Wellington North Solar Farm - EIS Exhibition

I refer to your email dated 14 August 2018 seeking comments from the Office of Environment and Heritage (OEH) on the Environmental Impact Statement (EIS) for the proposed Wellington North Solar Farm Project.

OEH review of Wellington North Solar Farm EIS

Figure 3-4 Vegetation zones in the development site (north).

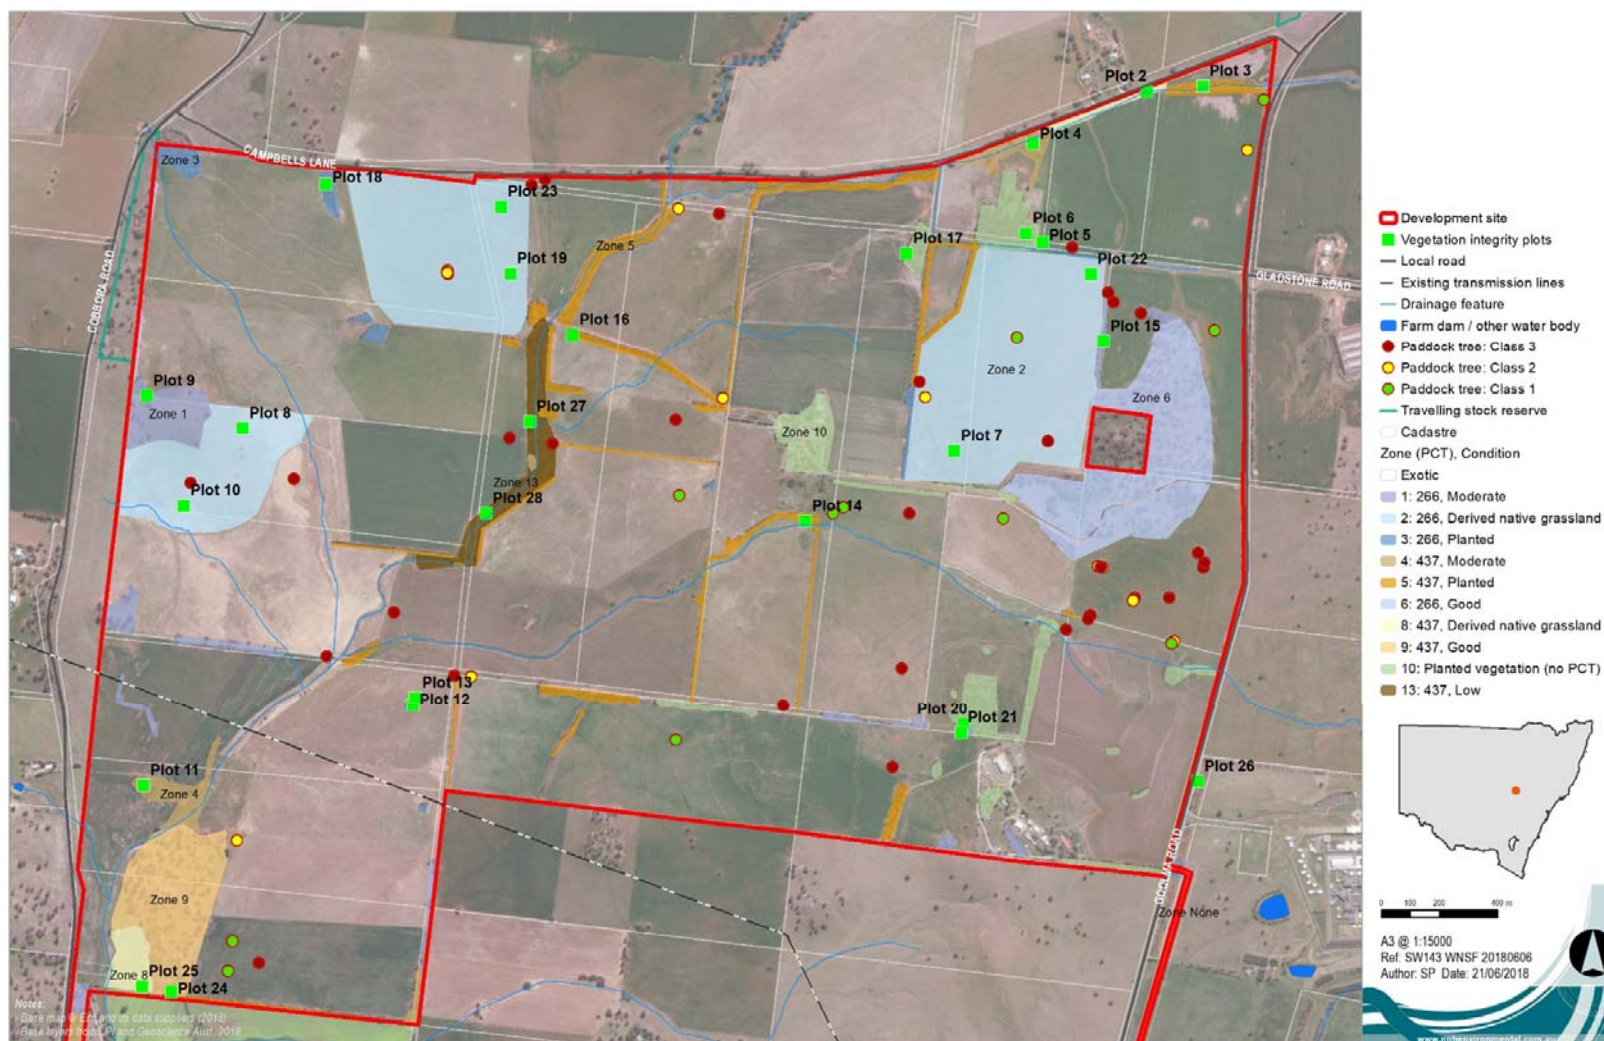
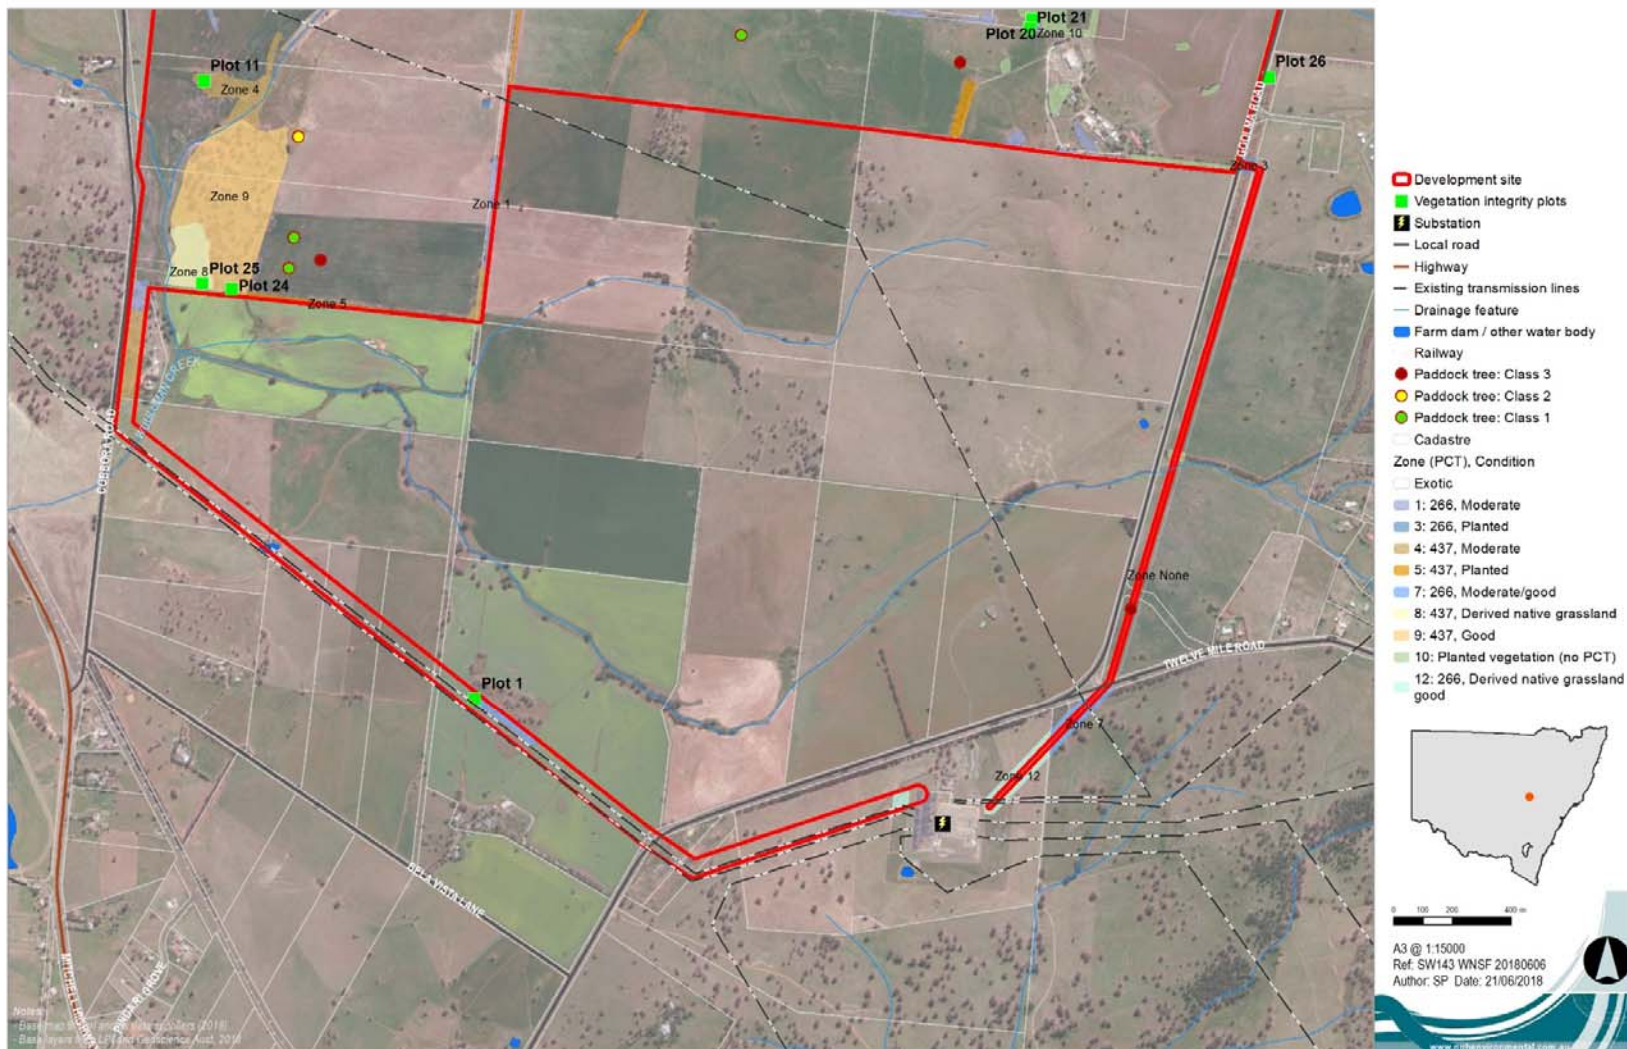
Table 3.3 of the BDAR details the size of each vegetation zone in the study area and the number of plots sampled. The number of plots required under the Biodiversity Assessment Method (BAM) is provided in Table 4 of the BAM. OEH notes that fewer than the required number of plots were sampled in Zones 4, 7, 12 and 13. This was also the case in Zones 6, 8 and 9, although impact in these zones have been avoided, as well as Zones 10 and 11. Vegetation in these last two zones are either exotic or planted non-local vegetation and do not require assessment.

Plot data is required to determine the vegetation integrity scores. Failure to complete the required number of plots is a failure to comply with the BAM.

3.1 The minimum number of plots for each vegetation zone for which impact is planned must be sampled.
